Our ref: NO/2022/114950/04-L01
Your ref: 3/2022/1003
Date: 06 April 2023

**DISCHARGE OF CONDITION 21 (COMPENSATORY STORAGE) FROM PLANNING PERMISSION 3/2021/0205.
LAND AT NEDDY LANE, BILLINGTON, BB7 9LL**

Environment Agency position

Pre & Post Development Floodplain
Sheet 2 of 8

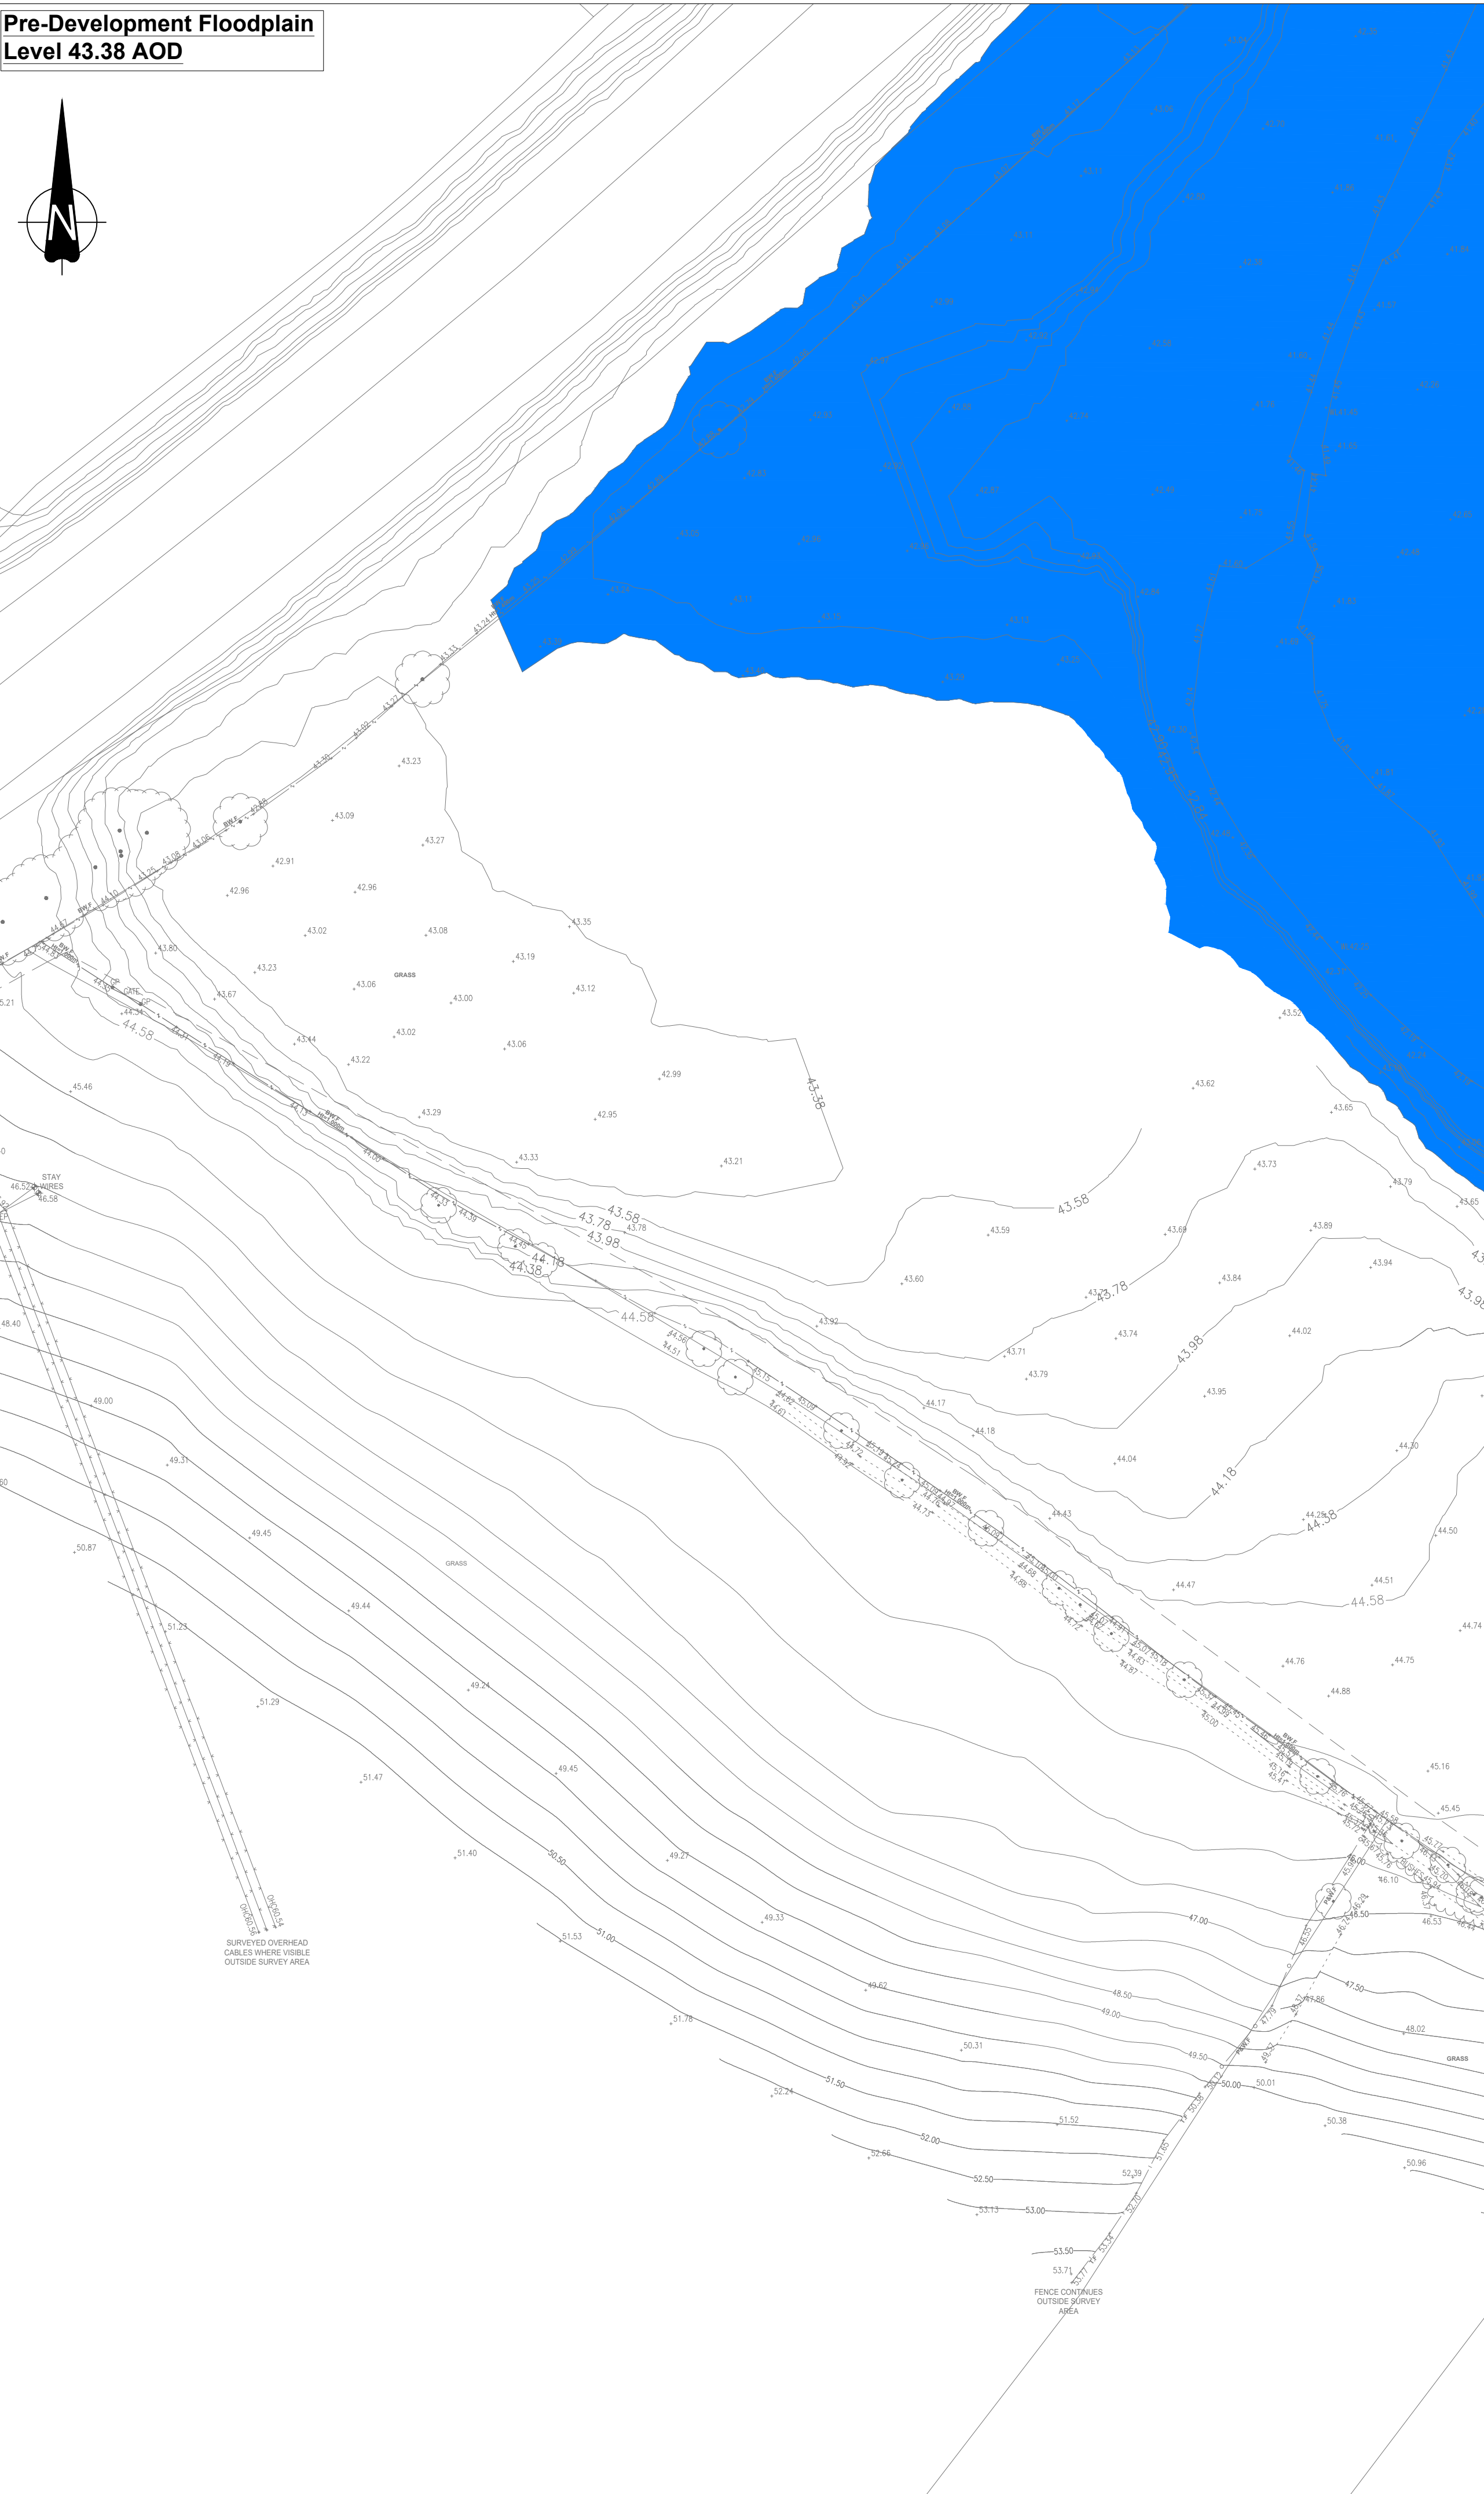
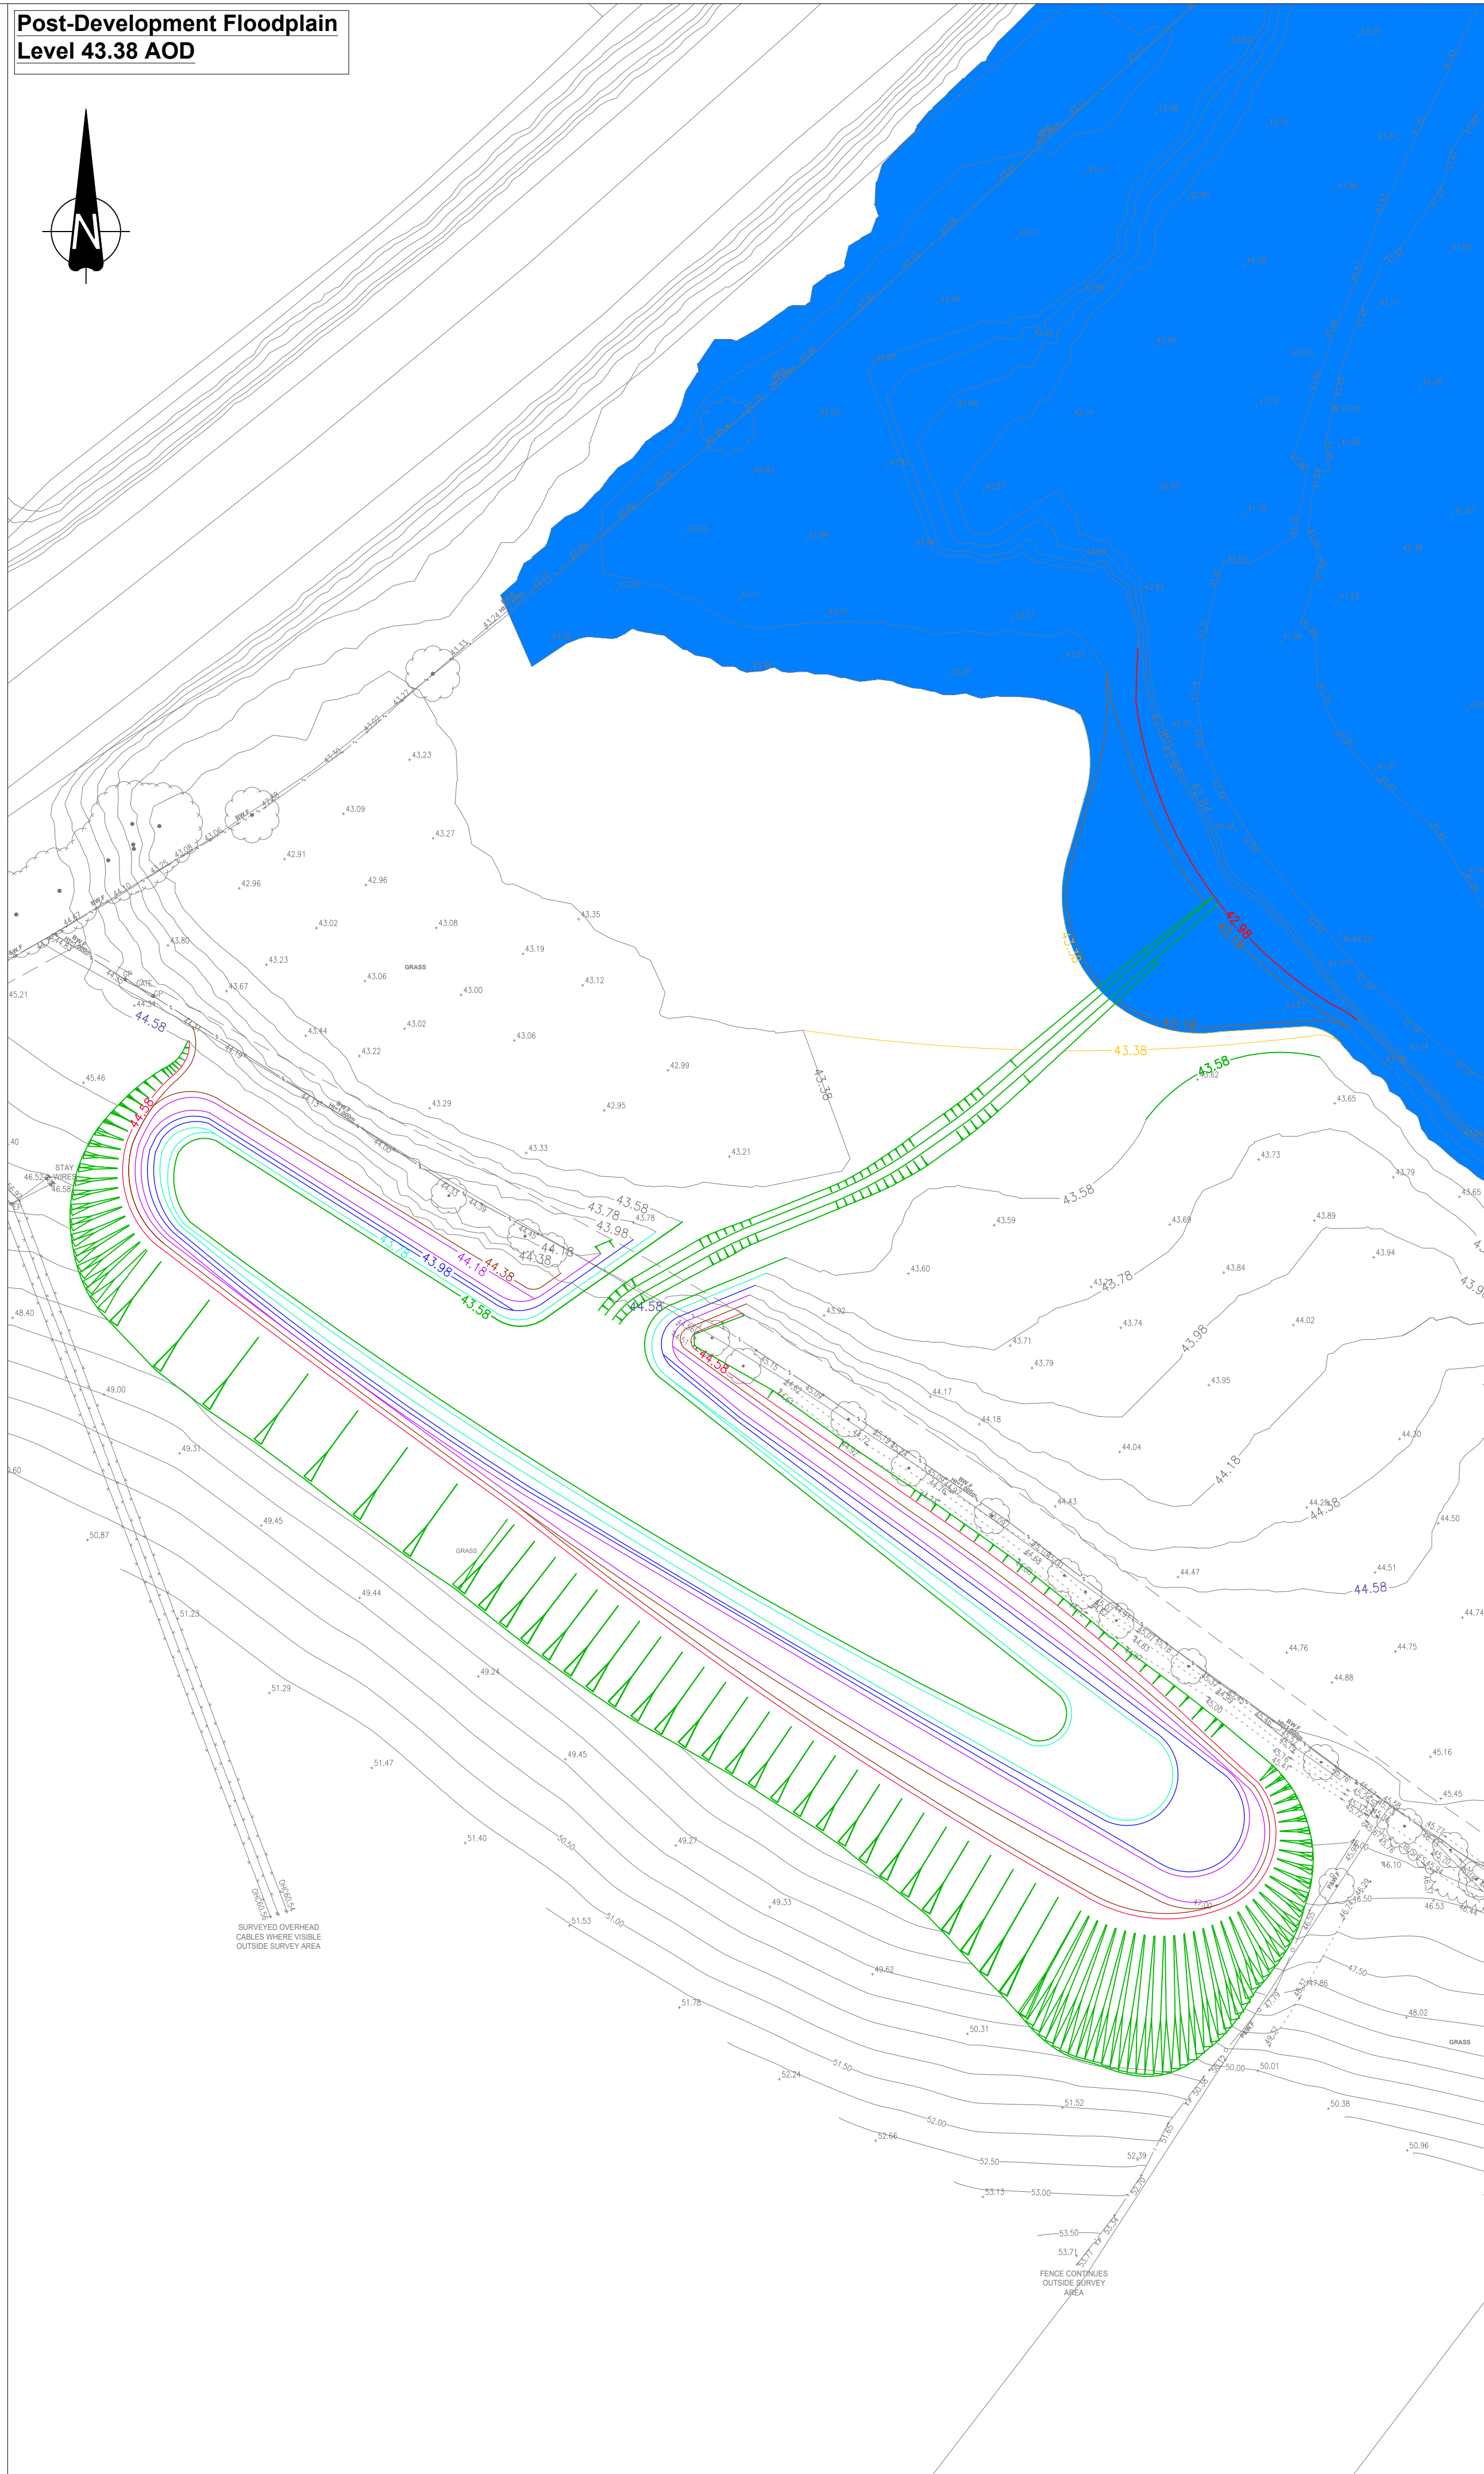
We have reviewed the details submitted to the LPA on the 21st March 23. We assume that the drawings are intended to show how flood water will propagate into the proposed flood storage area at 200mm increments to provide the required 'level for level' compensatory storage required for the proposed development platform.

The drawings do not appear to be derived from 2d hydraulic modelling, but rather an exercise in colour filling the relevant contour polylines. Therefore, we remain very concerned that the proposals are being progressed along an engineering cut and fill basis. Unfortunately, this means that there is still insufficient information regarding how the compensatory storage area will fill and drain during and after a flood event. As the submitted details do not satisfy the concerns outlined in our letter of 3 March 2023, we are currently unable to recommend the discharge of condition 21.
